Project Name:	Proposed Residential Development, Hemingfield, Barnsley				
Client:	Hargreaves Land Limited				
Subject:	Technical Note - Response to Highways Consultation Comments				
BGH Reference:	23-160-004.04				
Date:	22 nd August 2024				
Prepared by:	P Pitcher	Checked by:	R Donaldson	Overview by:	S Wilkins

BMBC Highways DC Consultation Response

Drawing No: 23/160/SKH/007      Revision: E  
Job No: 23-160      Date: 13.10.23

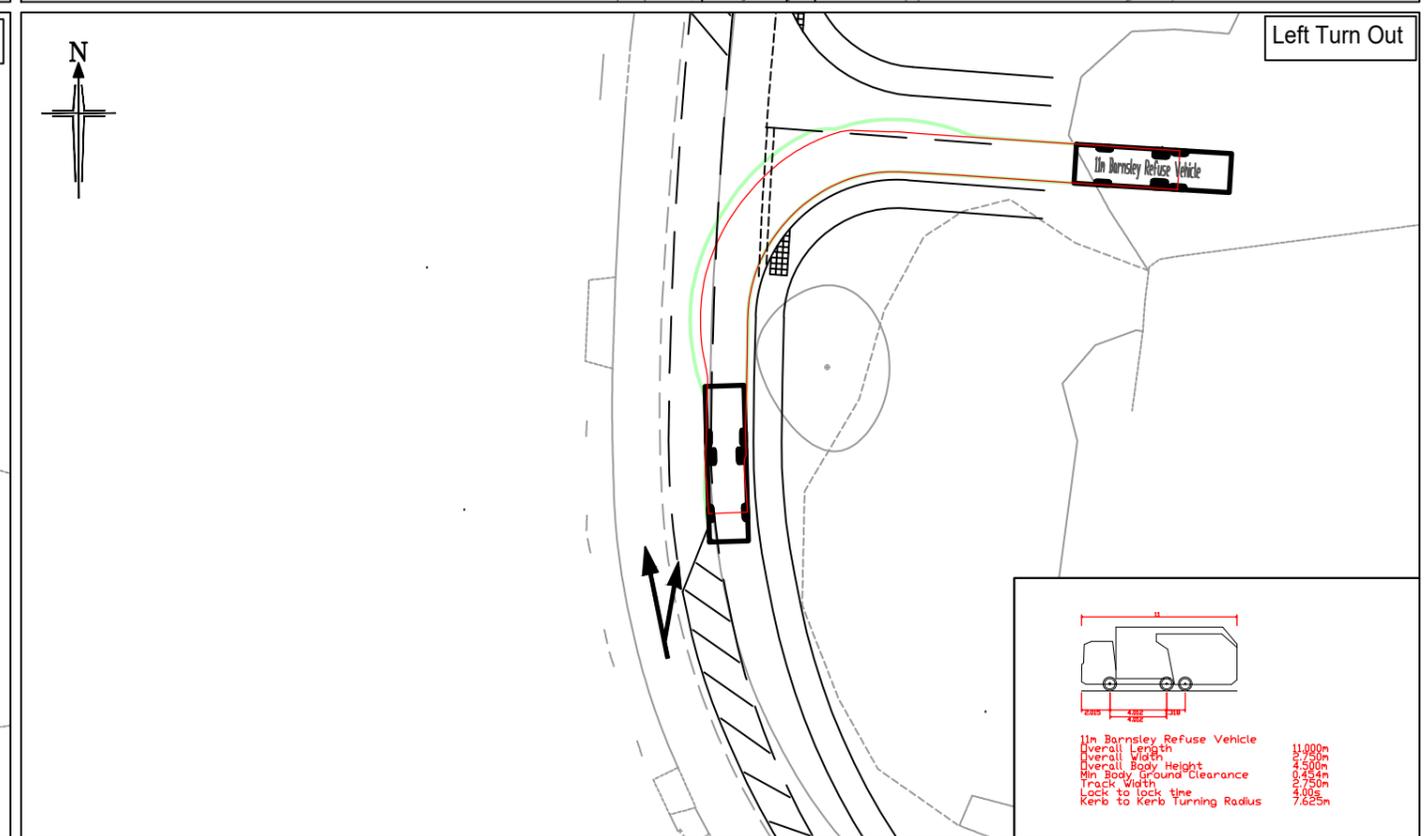
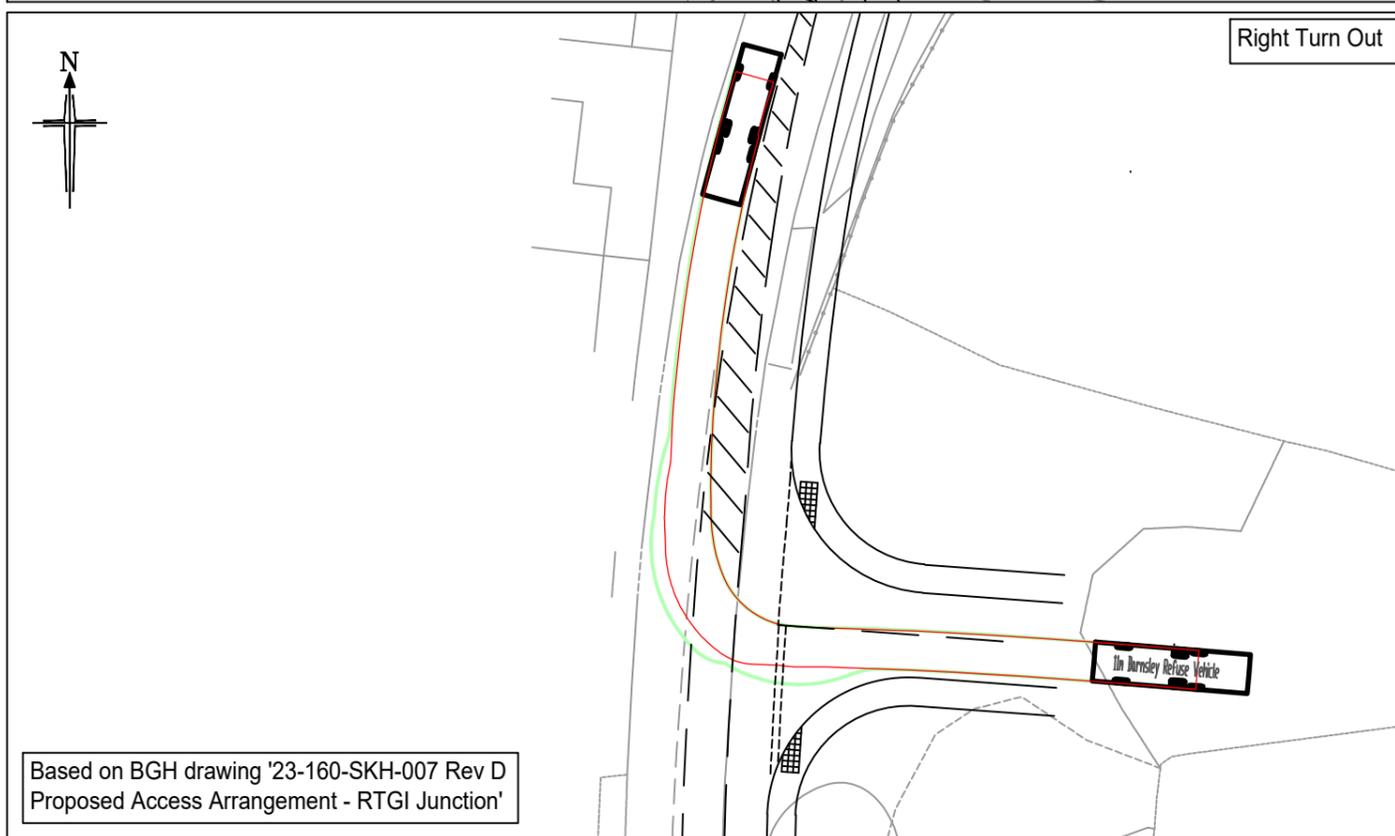
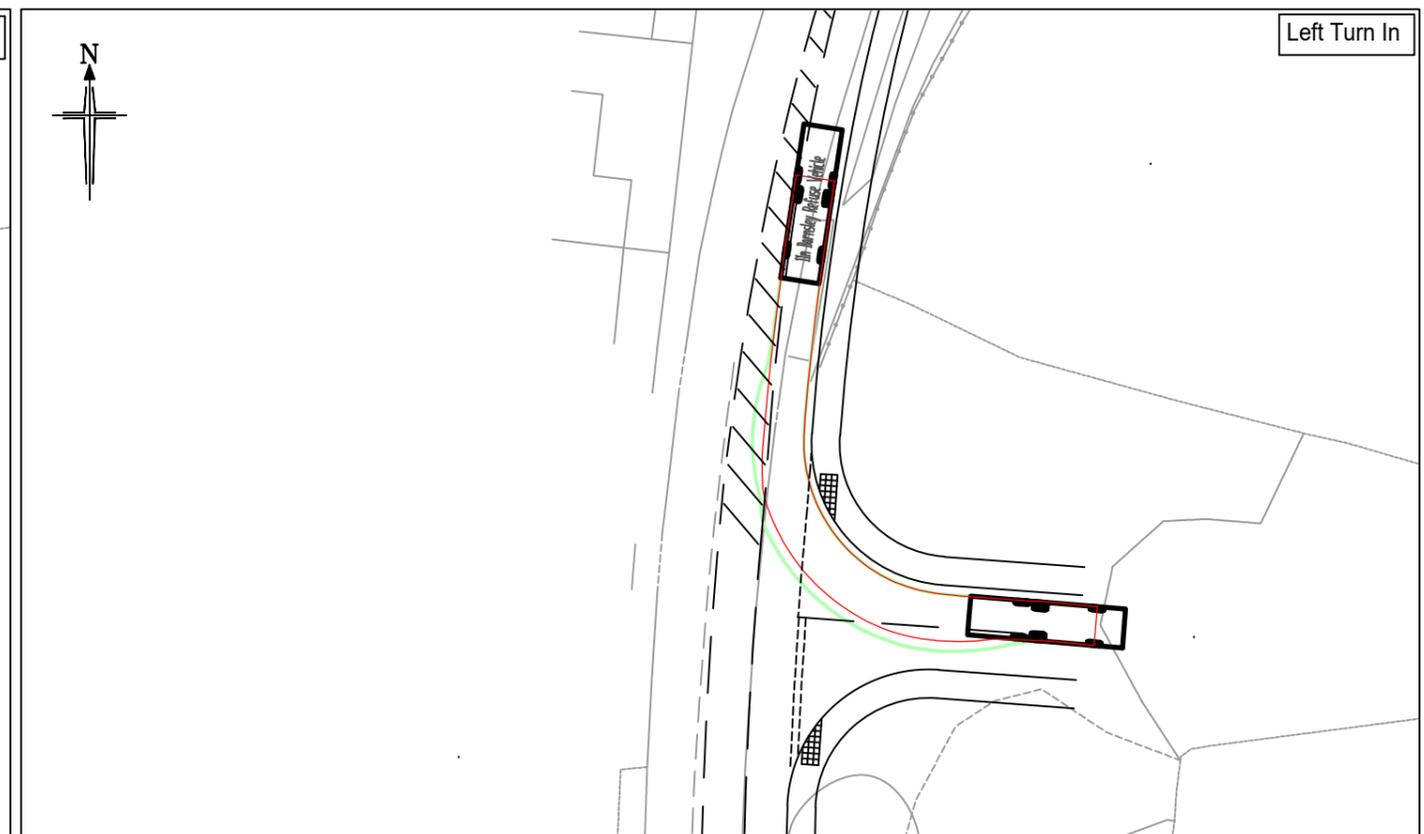
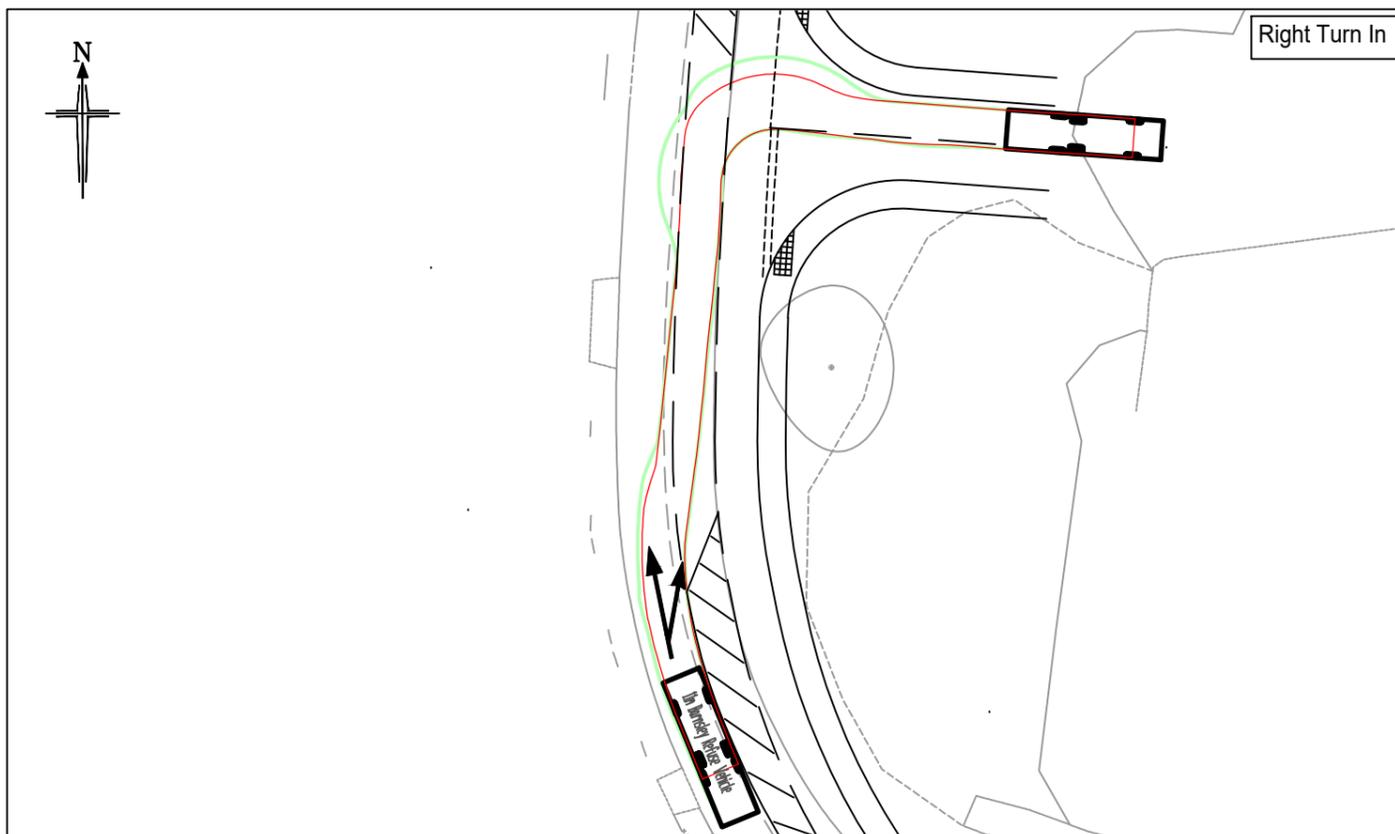
36. *"The refuse vehicle that requires tracking is as follows: Length 11 metres, width 2.75 metres, height 4.5 metres, weight 26 tonnes, turning circle needed 15.25 metres. A 0.5m gap from the edge of the carriageway or other obstruction should be maintained at all times when tracking vehicles. The tracking should therefore be updated."*

37. The refuse vehicle swept path analysis has been updated to reflect the specified vehicle measurements and this is attached at **Appendix BGH8** (23/160/ATR/001 Rev D). A 0.5 metre wide gap between the vehicle and the edge of the carriageway has been maintained when tracking the vehicle as requested by BMBC. The drawing shows that a refuse vehicle of this size can access and egress the site from Hemingfield Road, at the proposed site access junction.
